Project# 1004976

BORDENAVE DESIGNS agents for CALABACILLAS GROUP request the referenced/above actions for the P.U.E. on, and a portion of GOLF COURSE RD NW adjacent to, Tract A-1-A-1 **BLACK ARROYO DAM**, located on the west side of GOLF COURSE RD NW between WESTSIDE BLVD NW and the CALABACILLAS ARROYO containing approximately 8.0350 acres. (A-12)) [Deferred from 4/23/14, 5/7/14, 5/21/14]

Ref: Response to Review Comments May 15th DRB meeting- 13EPC 40091- HME Healthcare-
Westside and Golf Course

DEVELOPMENT REVIEW BOARD – SPEED MEMO

**BUILDING SIGNAGE CALCS:**

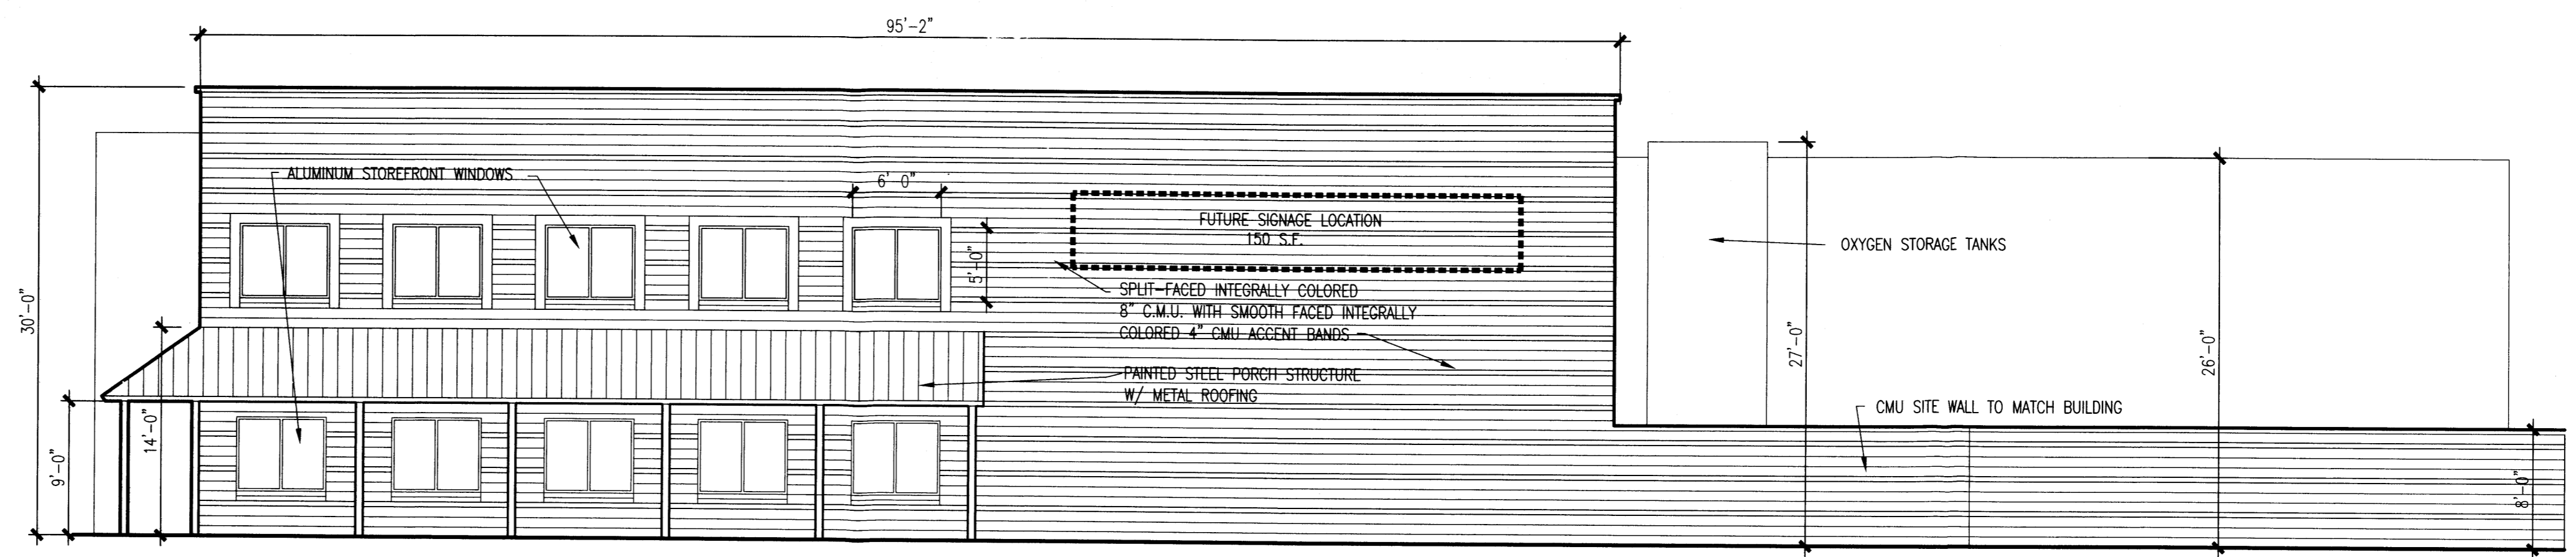
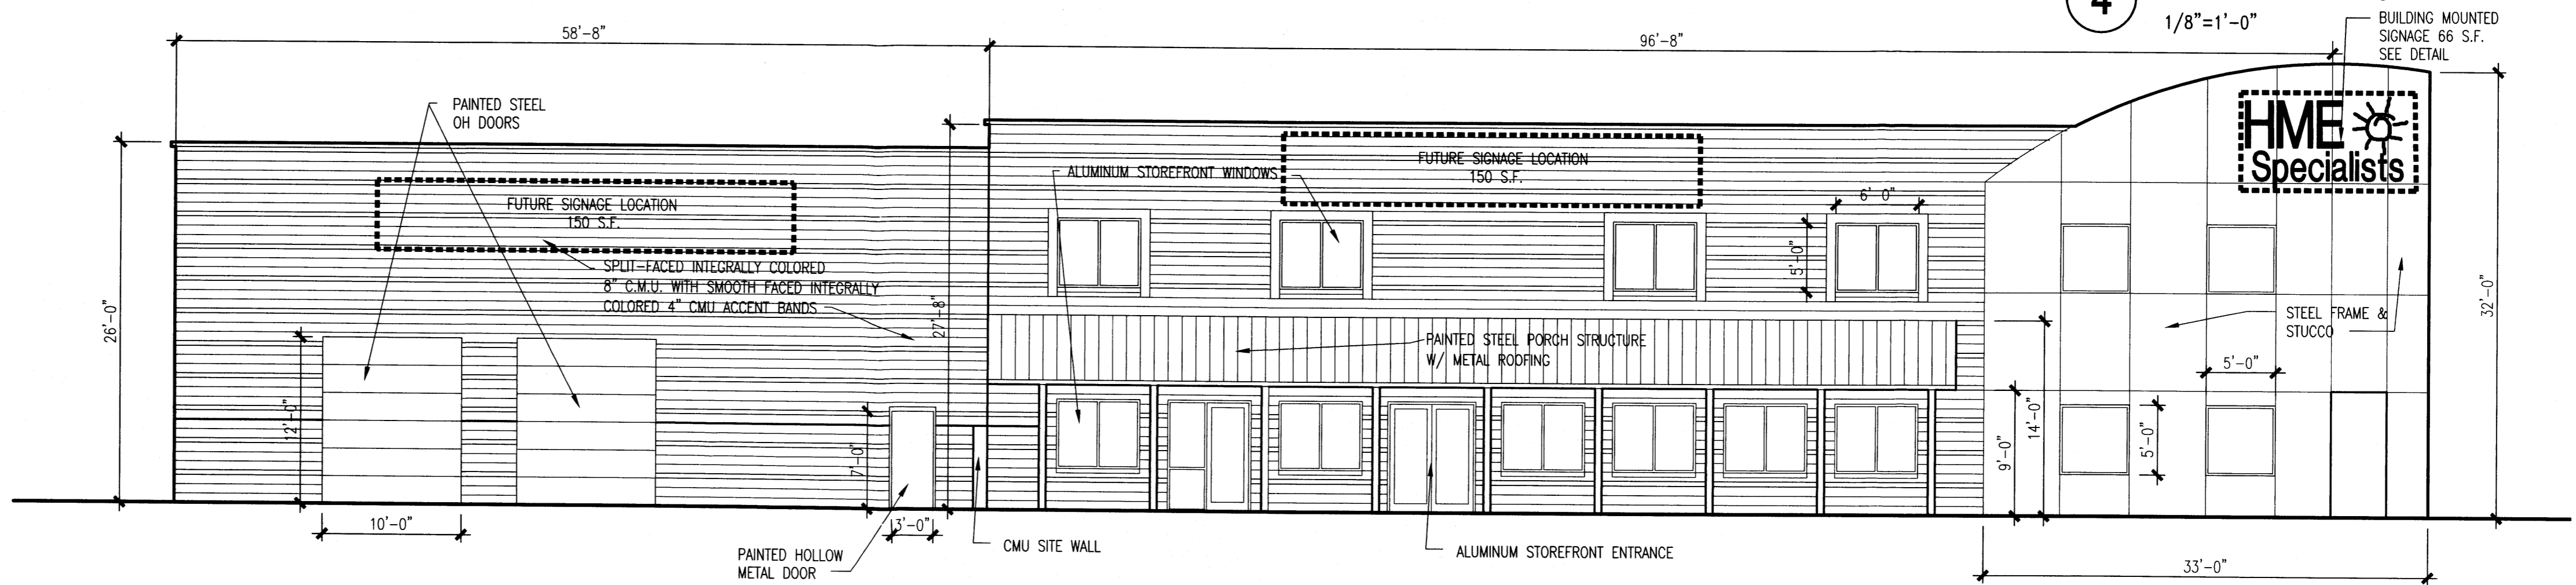
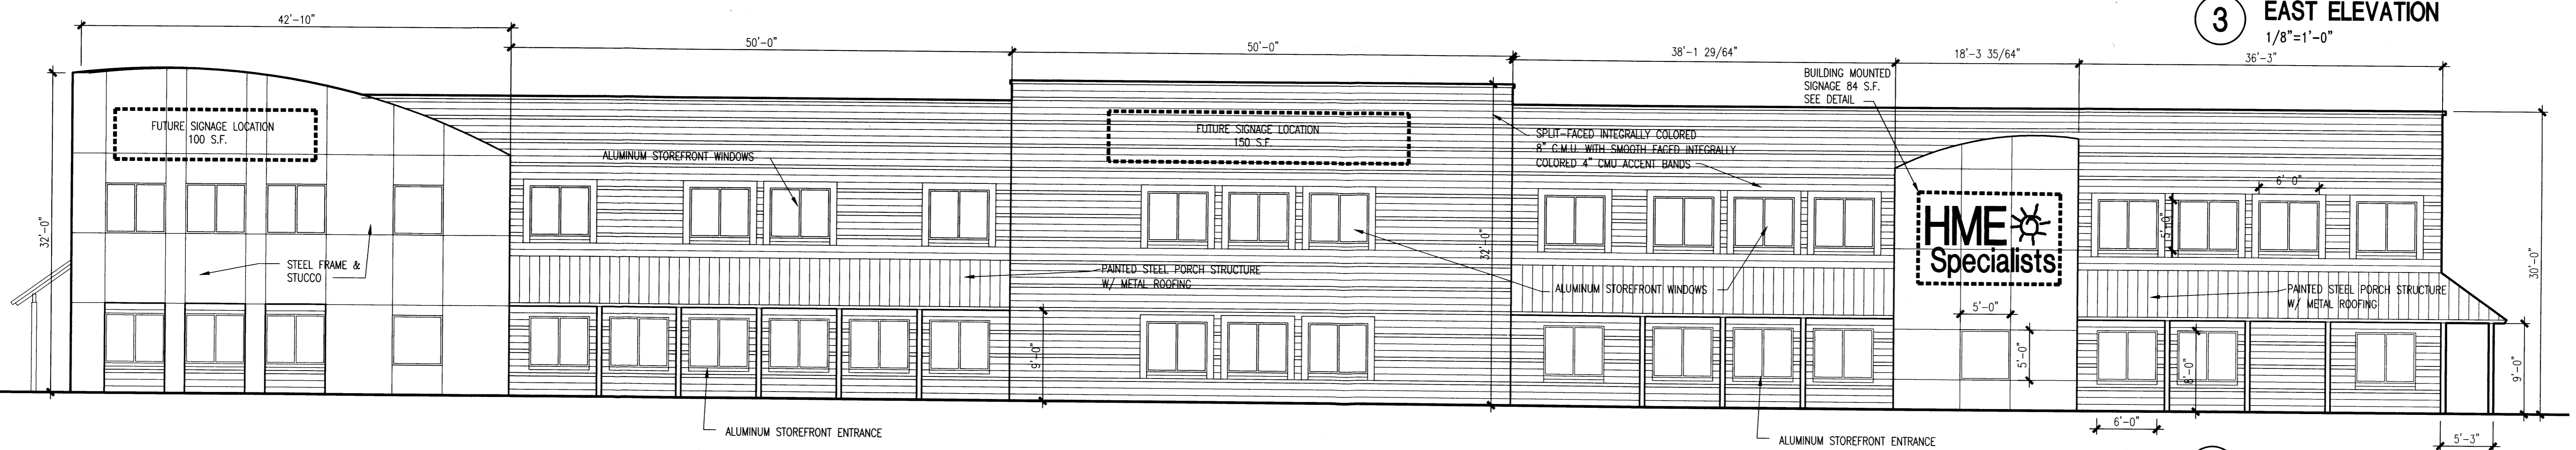
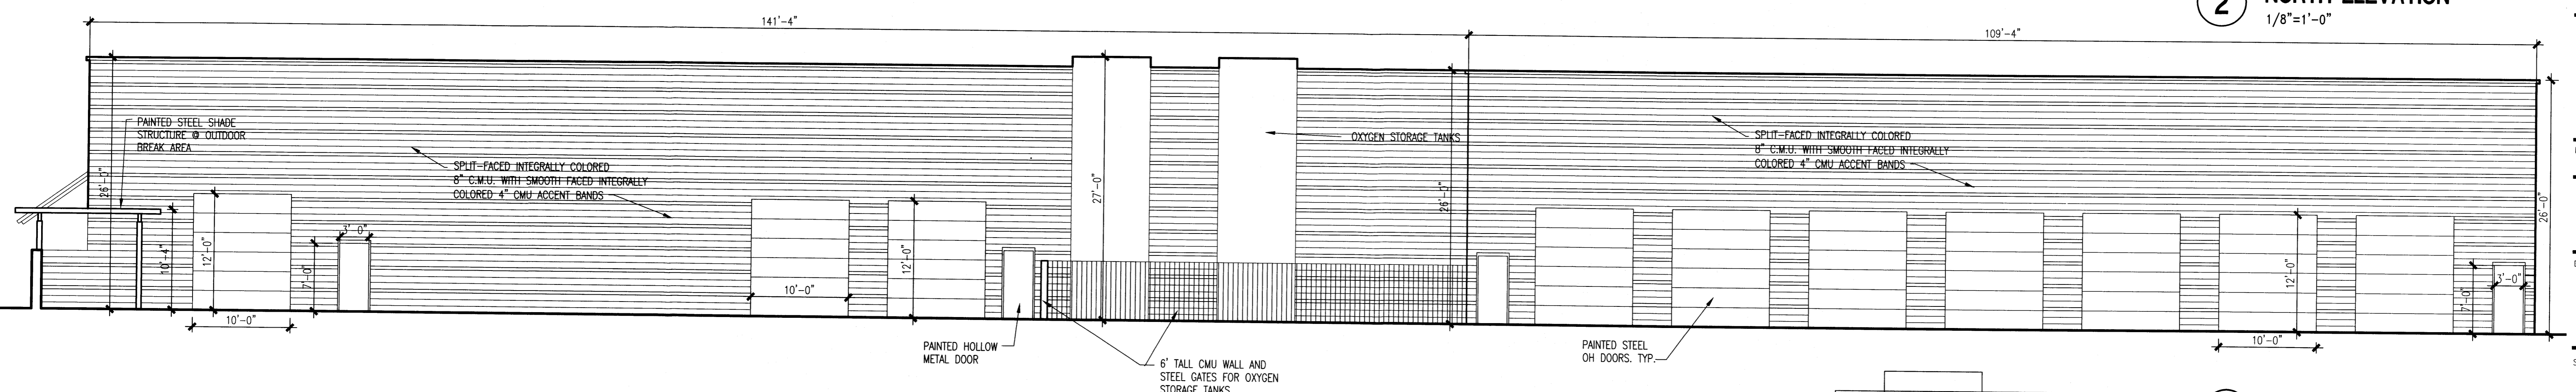
Condition 15A- Revised signage size to be 8%.

C0.2

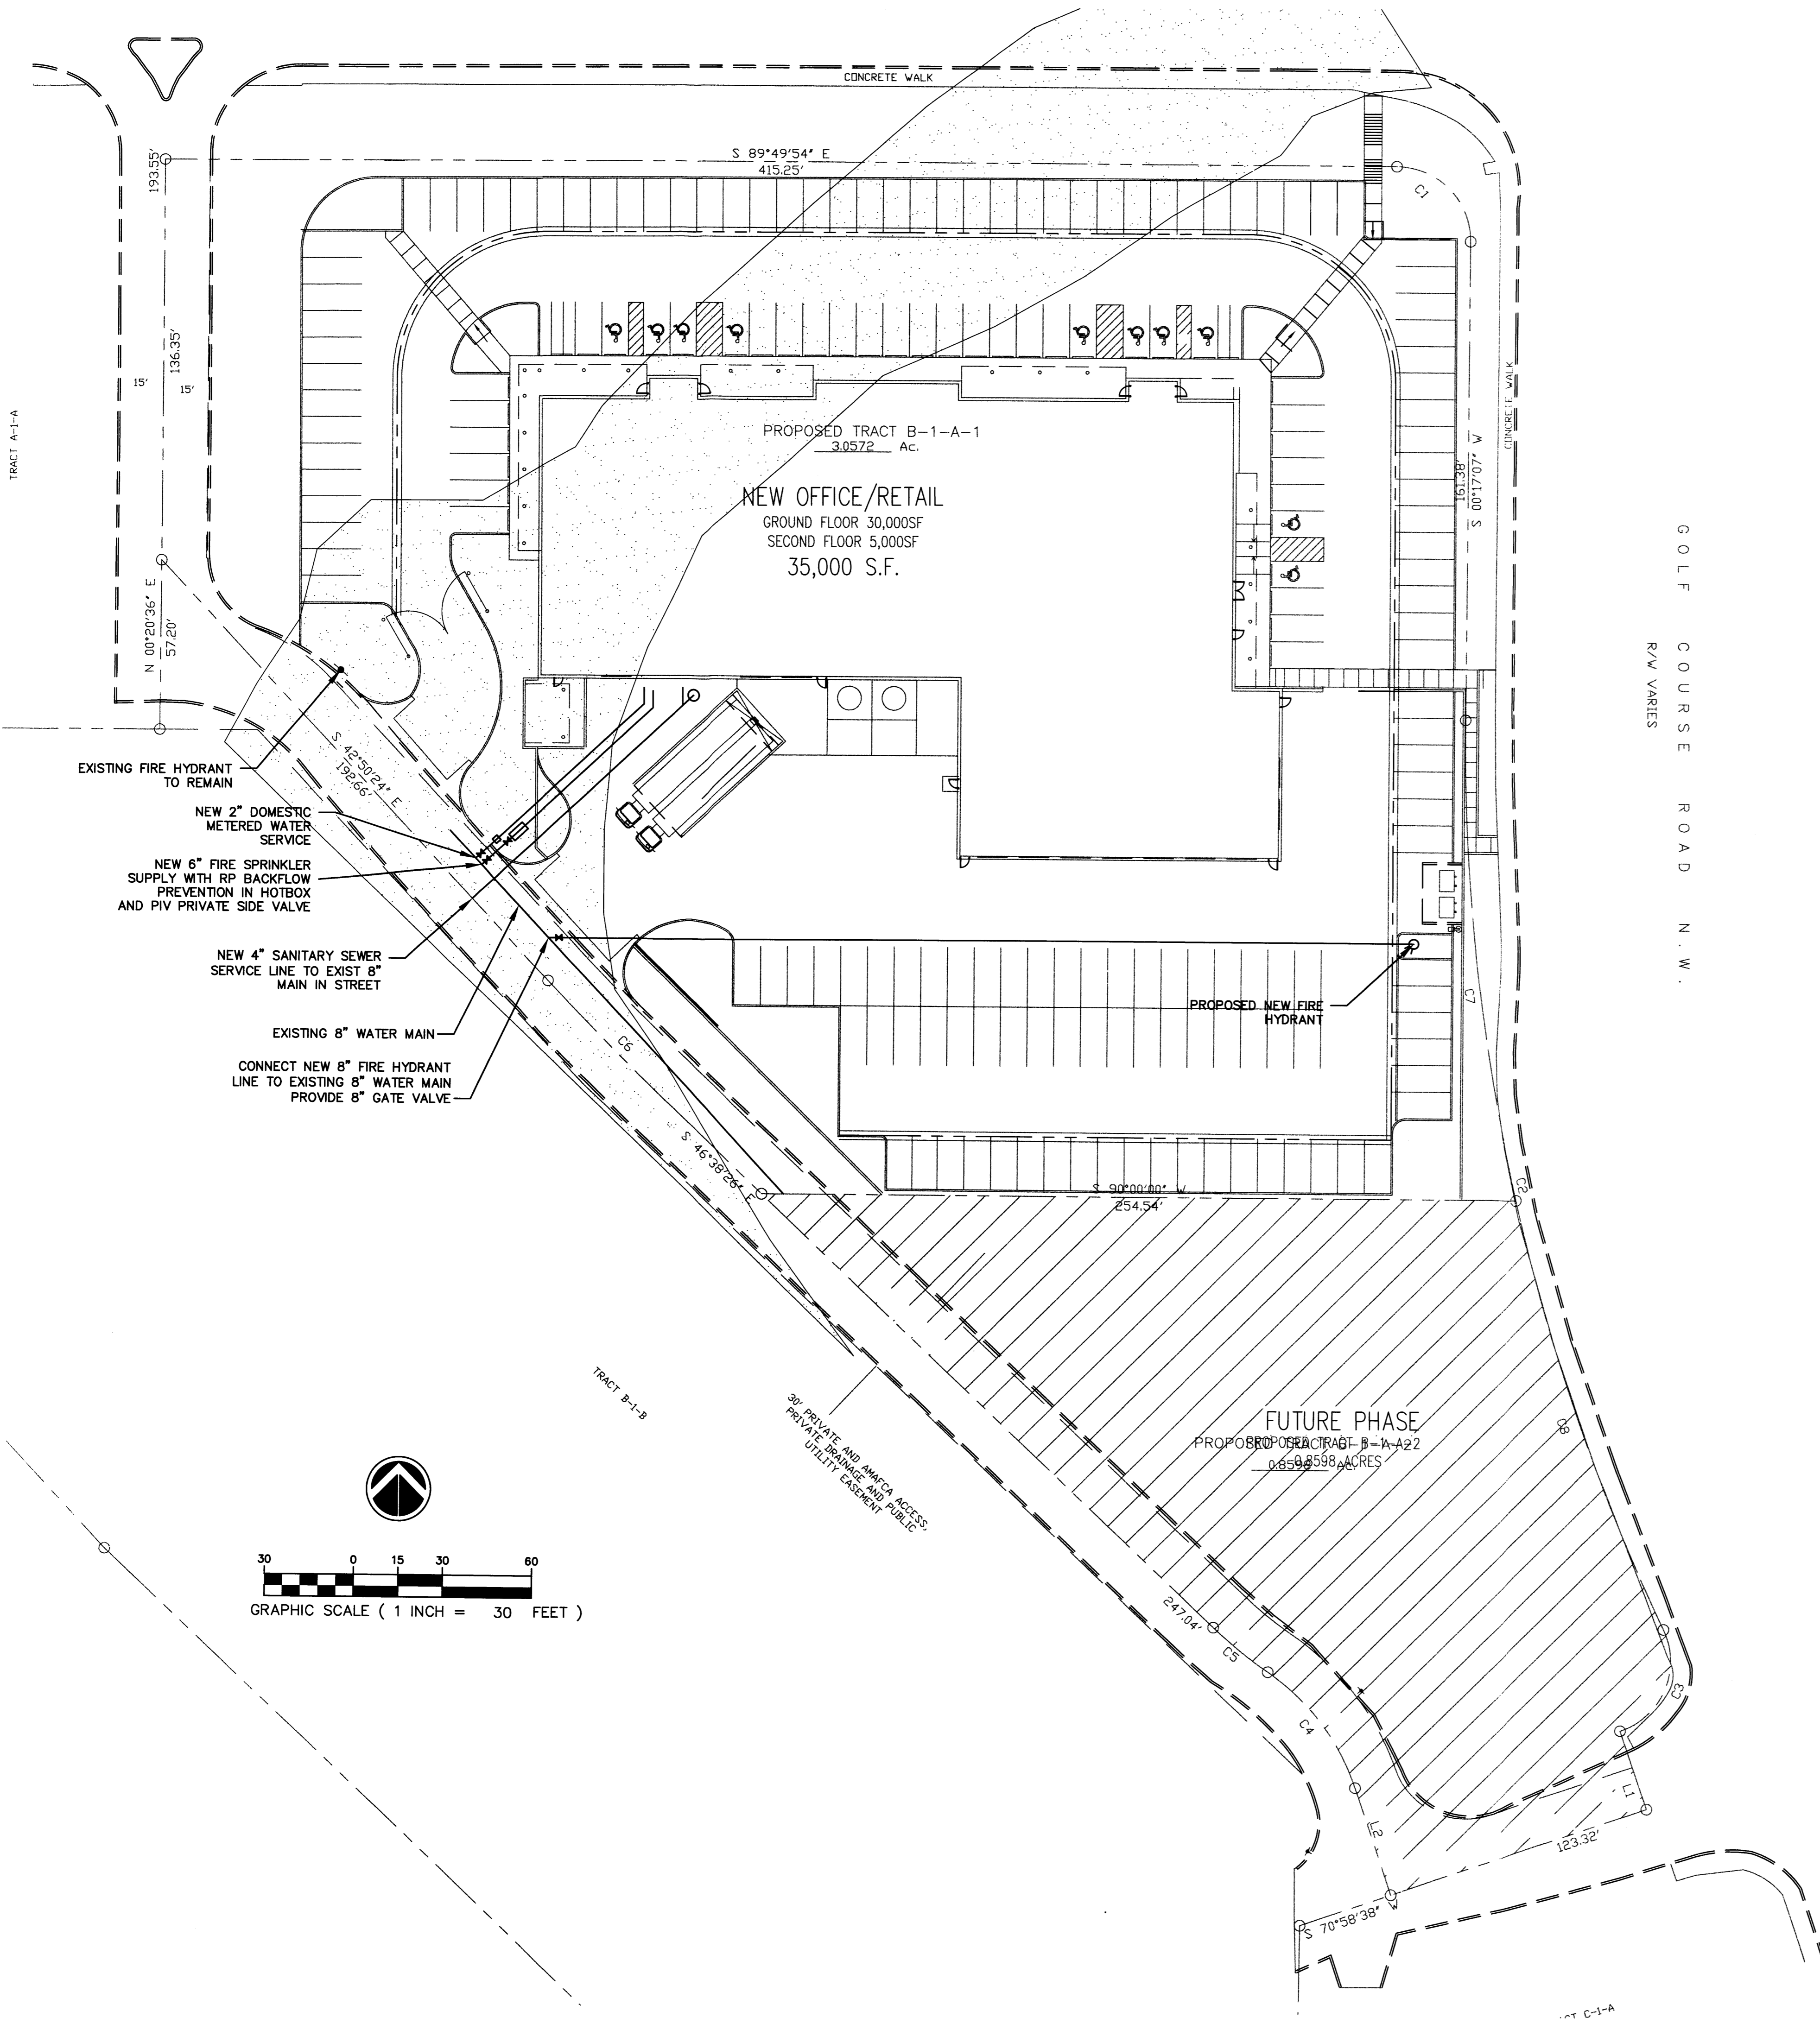
We met with Curtis and have developed a floodproofing measure that will remove the building from the flood plane. This involves a flood wall around the North end of the site that diverts the water around the building. This is shown on the conceptual grading and drainage plan. We understand the owner will still be required to purchase flood insurance until the LOMR is approved.
